Your Ref: OWPC22248
Our Ref: BR/85/19/HH 18-03-2019
Please ask for:
Andrew Wood

New 1st floor extension over rear projection.

31 Devonshire Road Bognor Regis

1 : 100

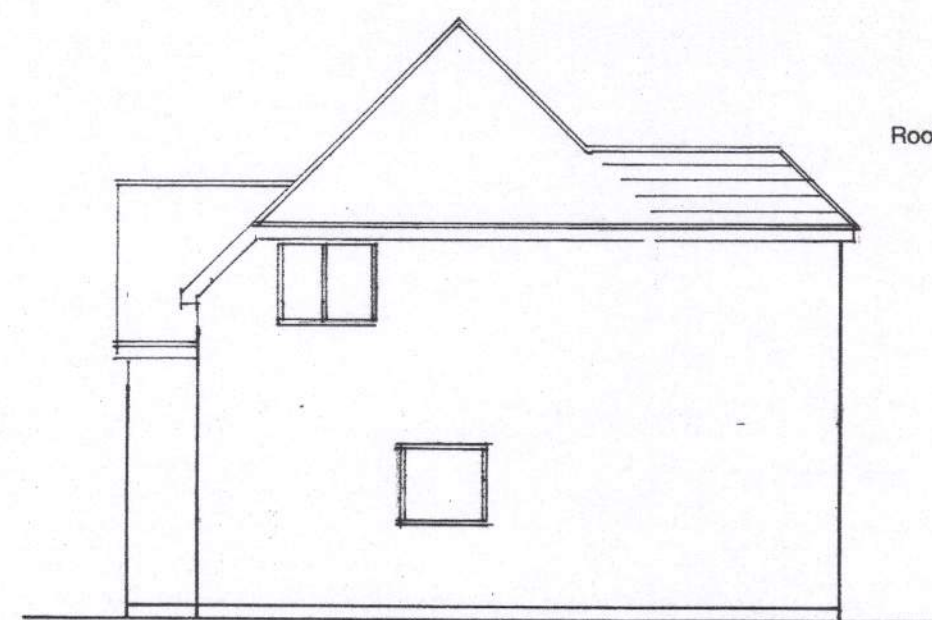
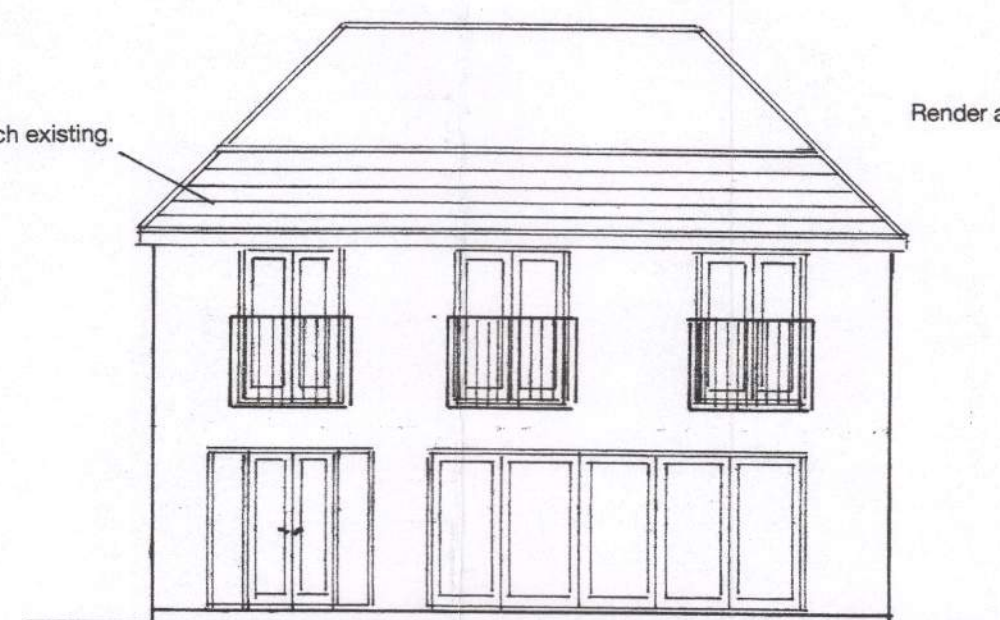
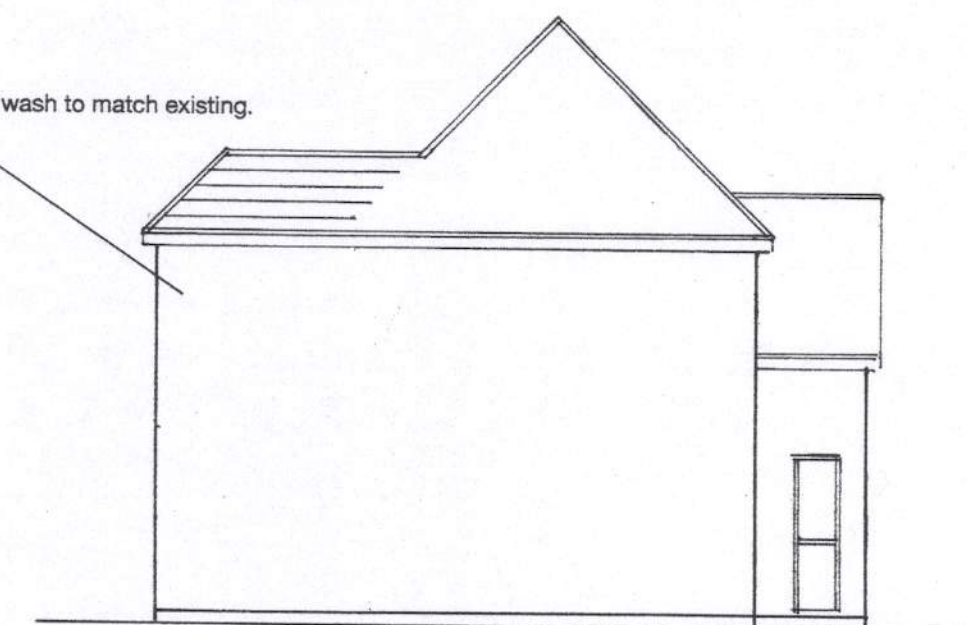
- 2. The original downstairs extension was allowed under a change of ruling in planning regulations in 2008 and we had no way of objecting to it.*
- 2. The height of the new roof will start on the 3rd tile above the level of the present roof (see photo in email attachment) and due to the proximity to our house, the development will certainly affect our daylight which was one of the reasons we bought this house 35 years ago .*

1st floor plan

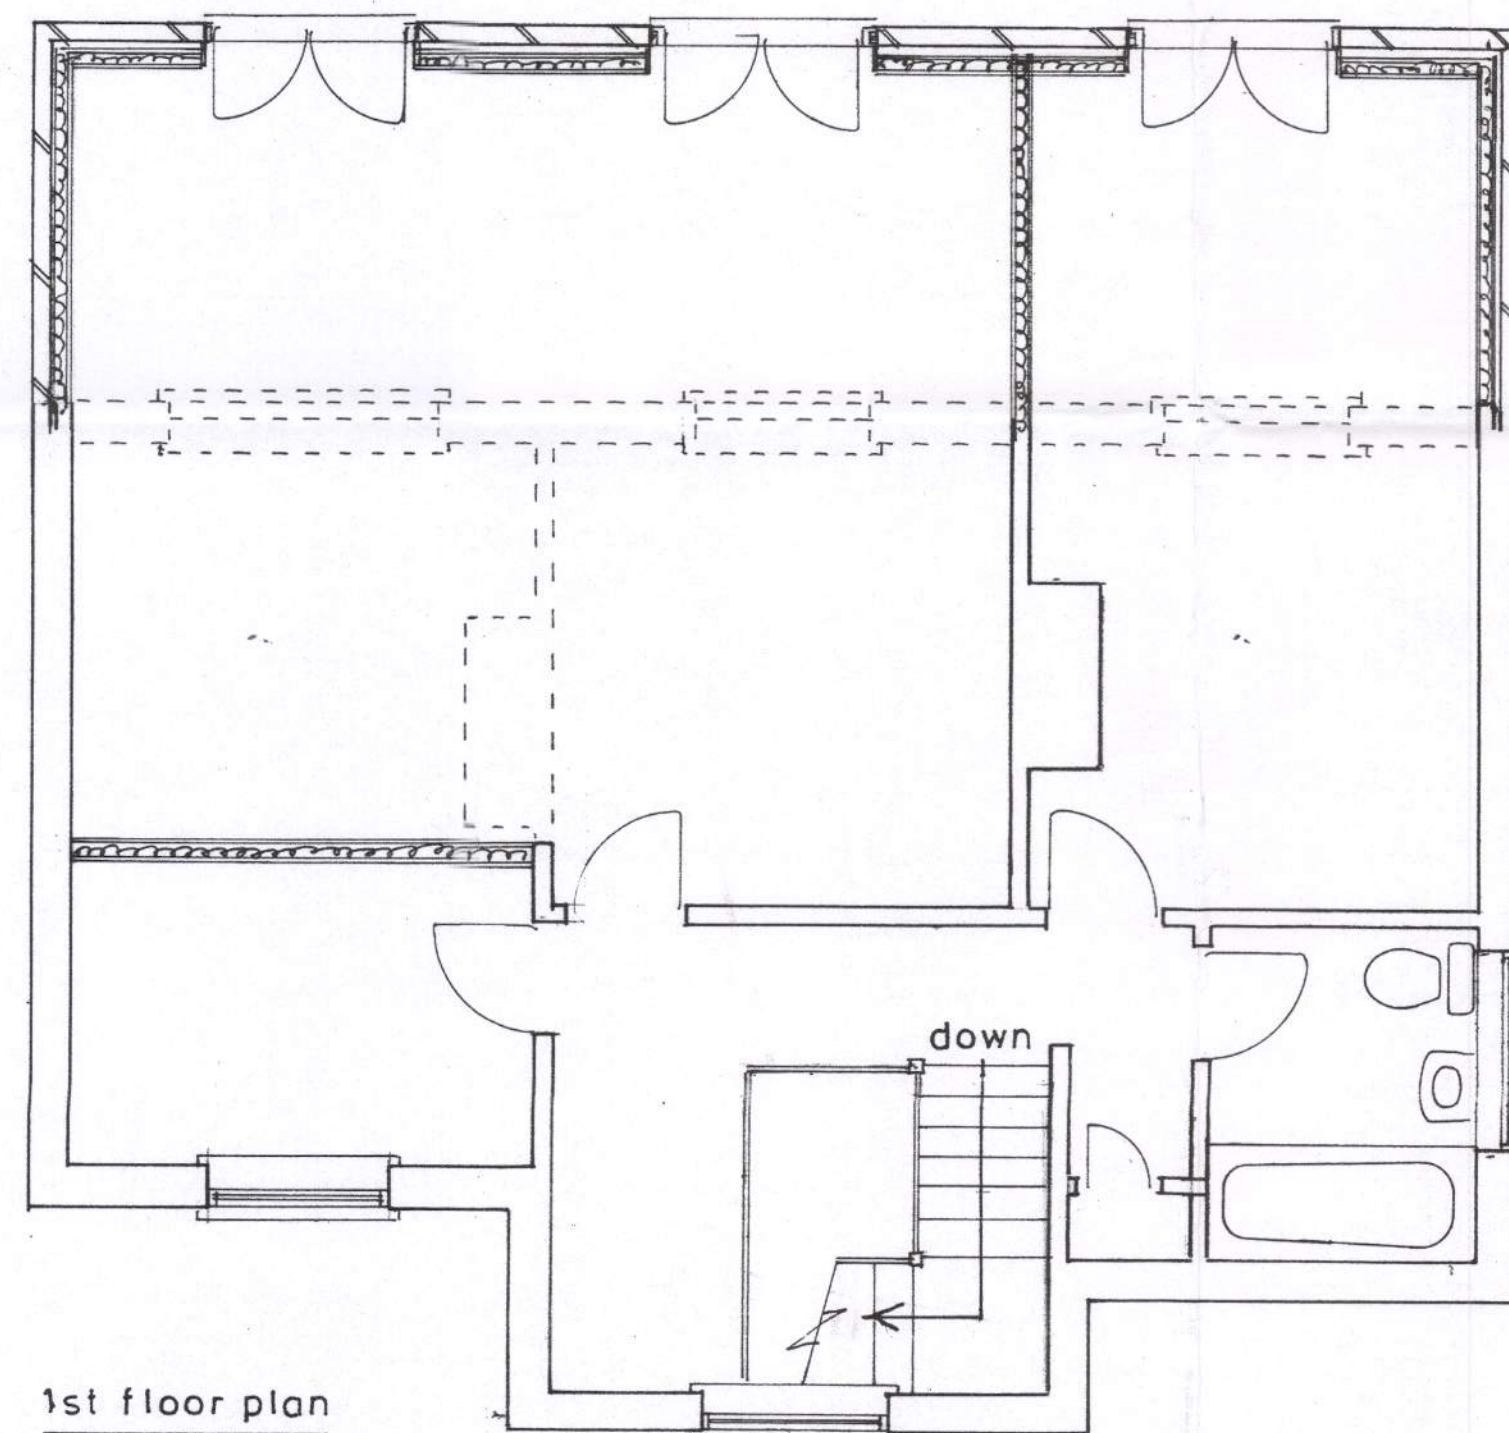
- 1. The plans for a first floor extension above the existing extension will seriously affect the light currently enjoyed both downstairs in the kitchen and upstairs in the bedroom in our home. (see photos attached in email).*

- 3. The plans also show 3 upstairs double doors on the extension with balconies instead of windows which will mean a total lack of privacy for us outside and in our garden as a result of people standing there and looking out.*
